Project Name: West Port Lofts
Project ID: 2015-182
Address: 22-28 Tate Street
Applicant: Tate Street Partnership, LLC
Planner: Nell Donaldson
CBLs: 44-E-15, 17, and 19

PLANNING BOARD REPORT PORTLAND, MAINE

West Port Lofts, 8-unit Condominium Development
22-28 Tate Street
Level III Site Plan and Subdivision Review
2015-182
Tate Street Partnership, LLC

C1.1
DATE

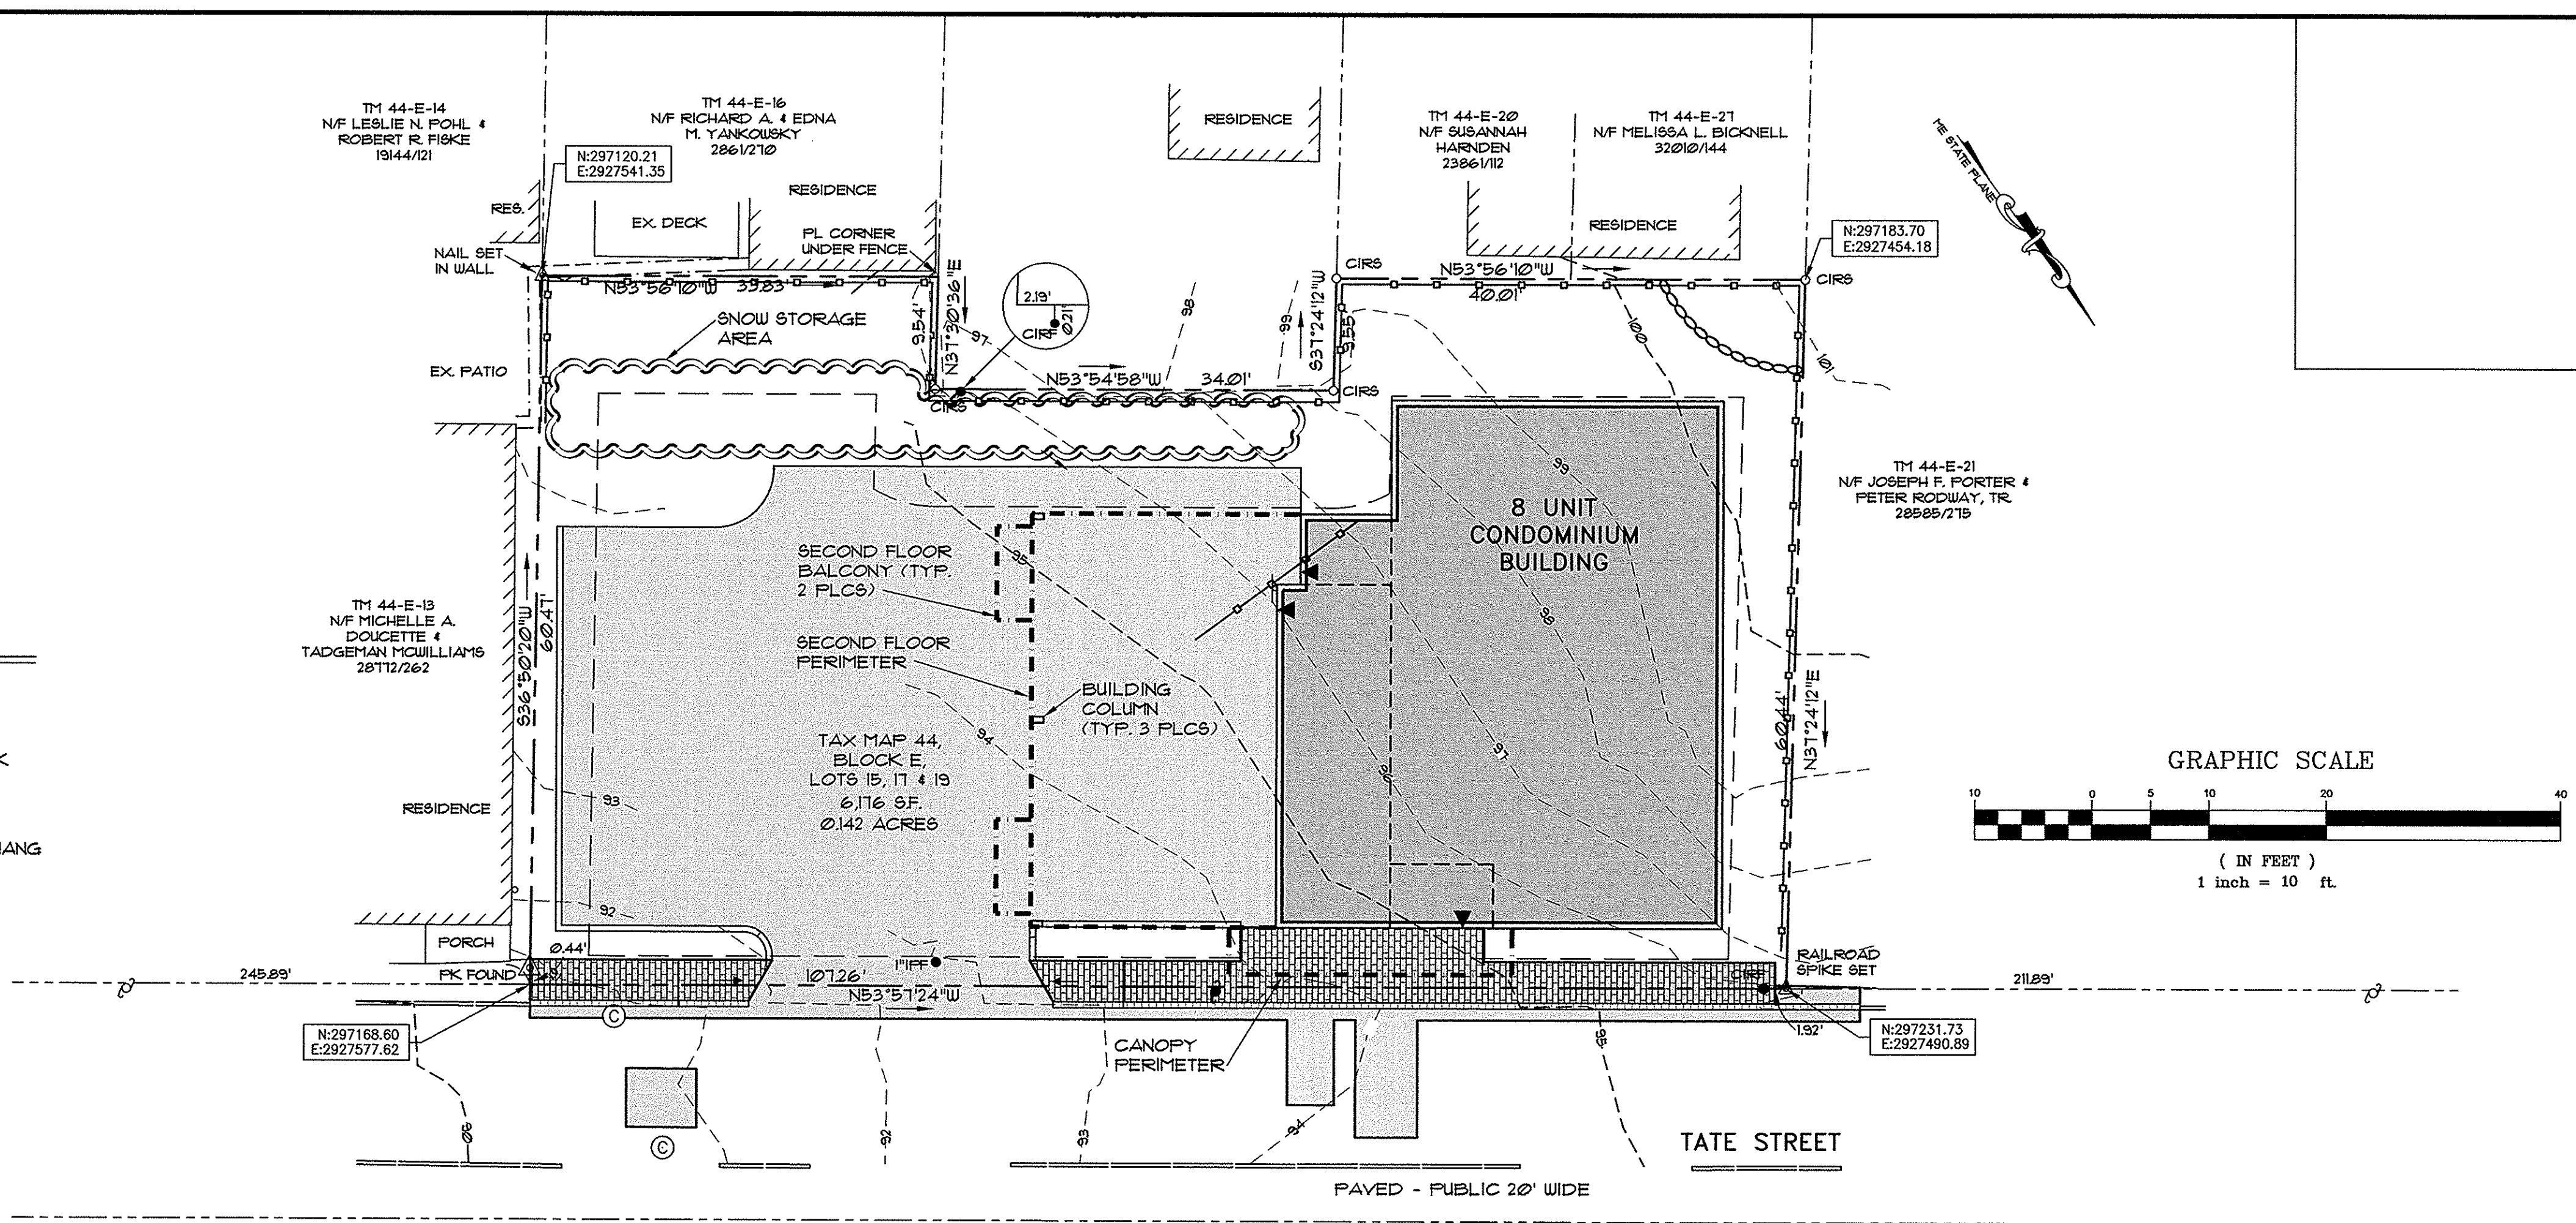
The Subdivision Plan needs to be stamped by a Professional Land Surveyor. This is a State of Maine requirement. Stamping of the plan by a non-licensed person is considered practicing surveying without a license subject to review and civil penalties by the State of Maine Board of Professional Land Surveyors.

Bearings and distances for the Proposed Pedestrian Access Easement to the City of Portland need to be added to the plan which will be used for the deed to the City of Portland.

Survey reference number 8 was not added referencing the ALTA/ACSM Land Title Survey by Owen Haskell, Inc. dated 9/16/2015.

A final plat addressing these comments and meeting the requirements of *Section 14-496* has been included as a condition of approval. A review of condominium documents has also been included as a condition of approval.

# First Floor Plan

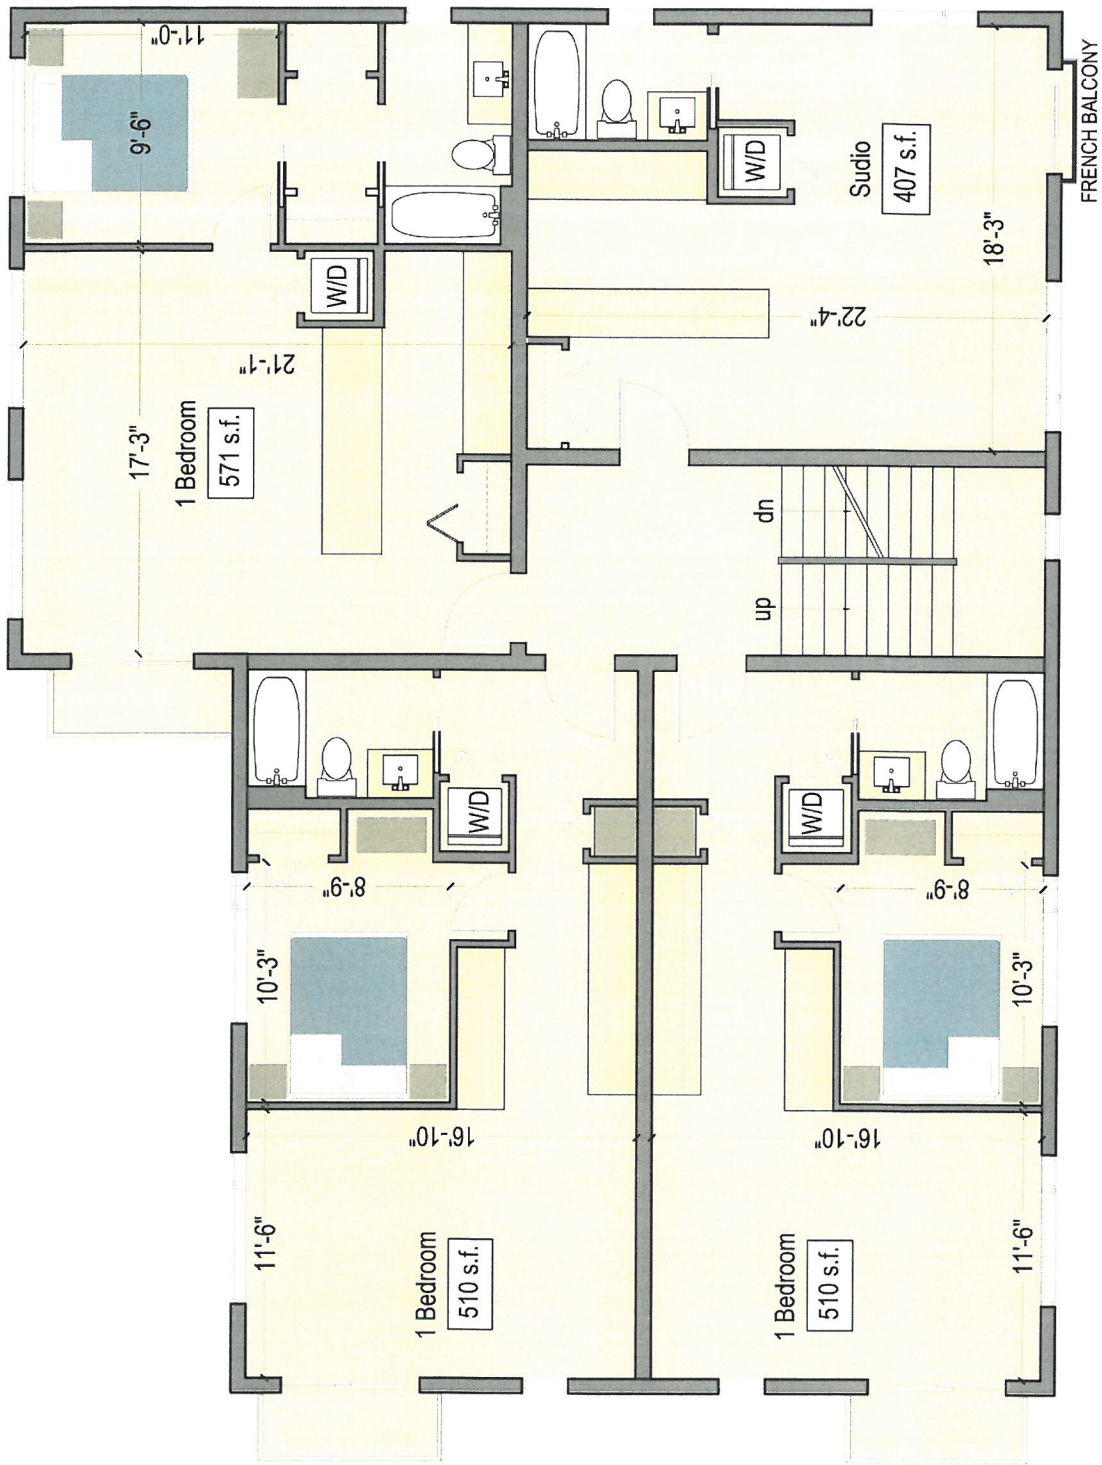
While the front building entrance is proposed at grade from Tate Street, access to all eight units from this entrance is proposed via interior stairwell, rendering them inaccessible from an ADA standpoint. The applicant writes that the Fair Housing Act and the Maine Human Rights Act apply in this case, and that both stipulate that in a building of over 4 units without an elevator, only ground floor units technically need to comply (*Attachment L*). In order to address accessibility to the ground floor unit then, the applicant has proposed “the building of a second entrance to the ground floor unit that is ‘lift ready’” at the rear (*Figure 6*). Mr. Errico has noted that the walkway between the public sidewalk and this secondary entrance, which is proposed at 3 feet in width, meets minimum ADA standards (*Attachment 3*). However, outstanding questions surrounding the location and conditional nature of this accessible rear entrance remain. Staff has

contracted with a third party reviewer in an effort to reach a resolution on the question of accessibility. However, that review was not available at the time of the writing of this report. As such, confirmation that the proposed plans are compliant with federal and state accessibility requirements has been included as a condition of approval.
